Yorkshire Water Services
Developer Services
Sewerage Technical Team
PO BOX 52
Bradford
BD3 7AY

Your Ref: 2024/92283
Our Ref: A004487

15th October 2024

Dewsbury Market, 32 Cloth Hall Street, Dewsbury – Redevelopment of market with addition of mezzanine floor

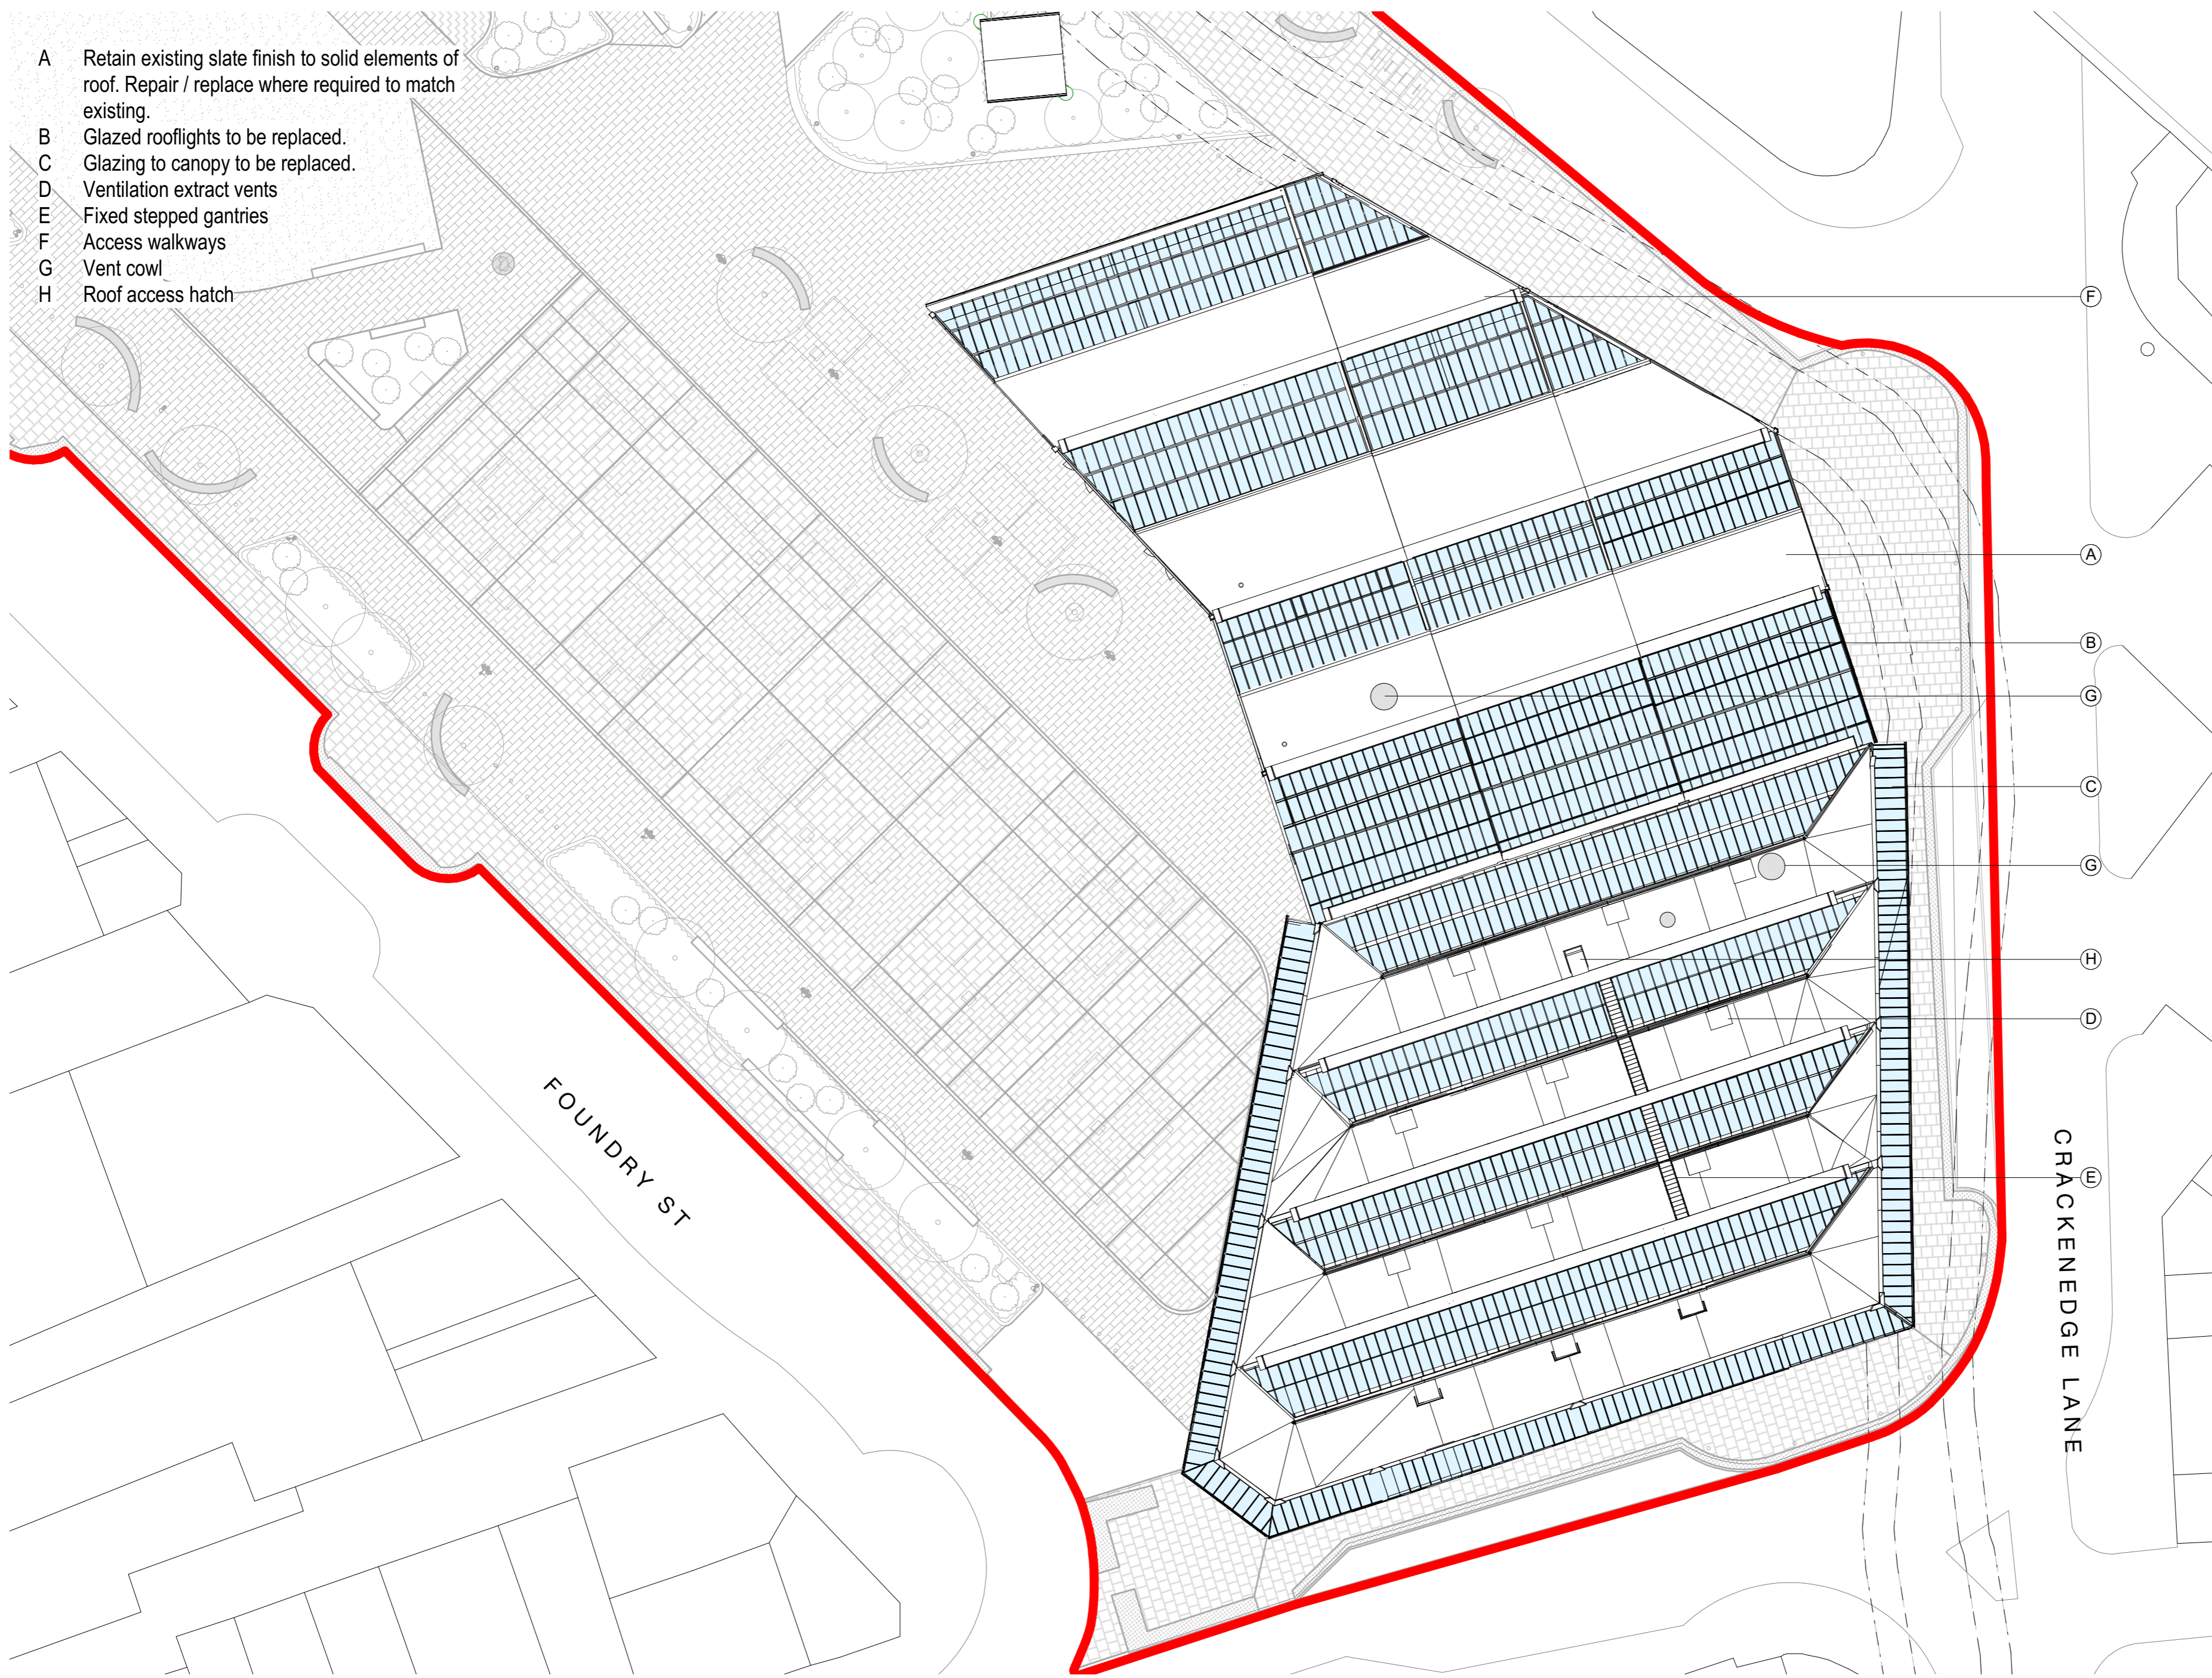
1.) The layout details submitted on drawing 'Market Building Proposed Roof Plan' DMTP-BDP-00-RF-PL-A-20002 (revision P04) dated 12/08/24 that has been prepared by BDP is not acceptable. The following point(s) should be addressed:

- a.) the submitted drawing appears to show a building proposed to be built-over the line of public water main crossing the site.
- b.) the submitted drawing should show the site-surveyed position of the public water main crossing the site.
- c.) the submitted drawing should show the required building easement from the water main crossing the site.

1.) The layout details submitted on drawing 'Market Building Proposed Roof Plan' DMTP-BDP-00-RF-PL-A-20002 (revision P04) dated 12/08/24 that has been prepared by BDP is not acceptable. The following point(s) should be addressed:

- a.) the submitted drawing appears to show a building proposed to be built-over the line of public sewer crossing the site.
- b.) the submitted drawing should show the site-surveyed position of the public sewer crossing the site
- c.) the submitted drawing should show the required building stand-off from public sewer -- or an agreed alternative scheme

- a.) There should be no building, obstruction or landscaping within 3 metres of this asset.
- b.) The position of these mains are indicative only and should be confirmed through site survey
- c.) Please contact Yorkshire water on 03451 242424 to arrange a site visit to map these assets (water mains only).
- d.) A proposal by the developer to alter/divert a public sewer will be subject to Yorkshire Water's requirements and formal procedure in accordance with Section 185 Water Industry Act 1991.

b.) In this instance, a stand-off distance of 3.5 (three point five) metres is required at each side of the sewer centre-line and it may not be acceptable to raise or lower ground levels over the sewer, nor to restrict access to the manholes on the sewer.

SITE BOUNDARY
	EXISTING LEVEL RETAINED
	PROPOSED LEVEL
	PROPOSED GRADIENT
	DFE WATER MAIN
	PUBLIC SEWER LINE
	3M WATER MAIN OFFSET NO TREES WITHIN 5M
	3.5M SEWER OFFSET NO BUILDINGS/STRUCTURES WITHIN OFFSET

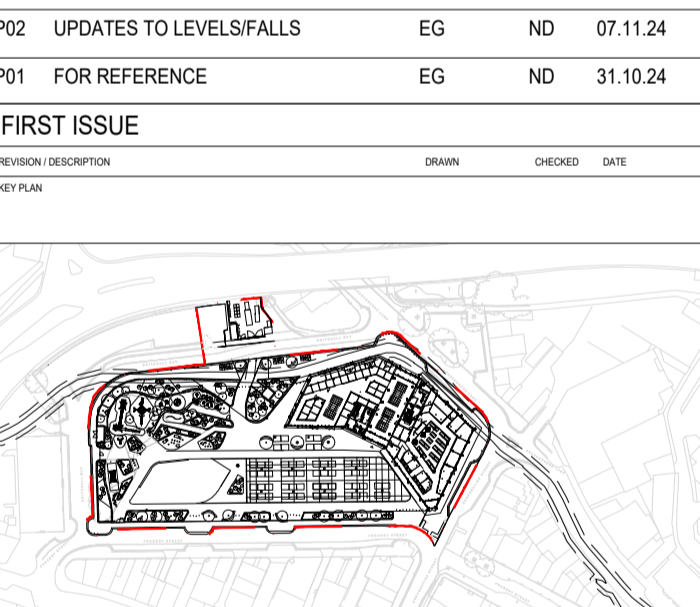
2.) On The statutory water main map there is a 125mm DPE water main and an abandoned 70mm water main recorded to cross the site.

2.) On the Statutory Sewer Map, there is a 450 & 375 mm diameter public combined water sewer recorded to cross the site. It is essential that the presence of this infrastructure is taken into account in the design of the scheme.
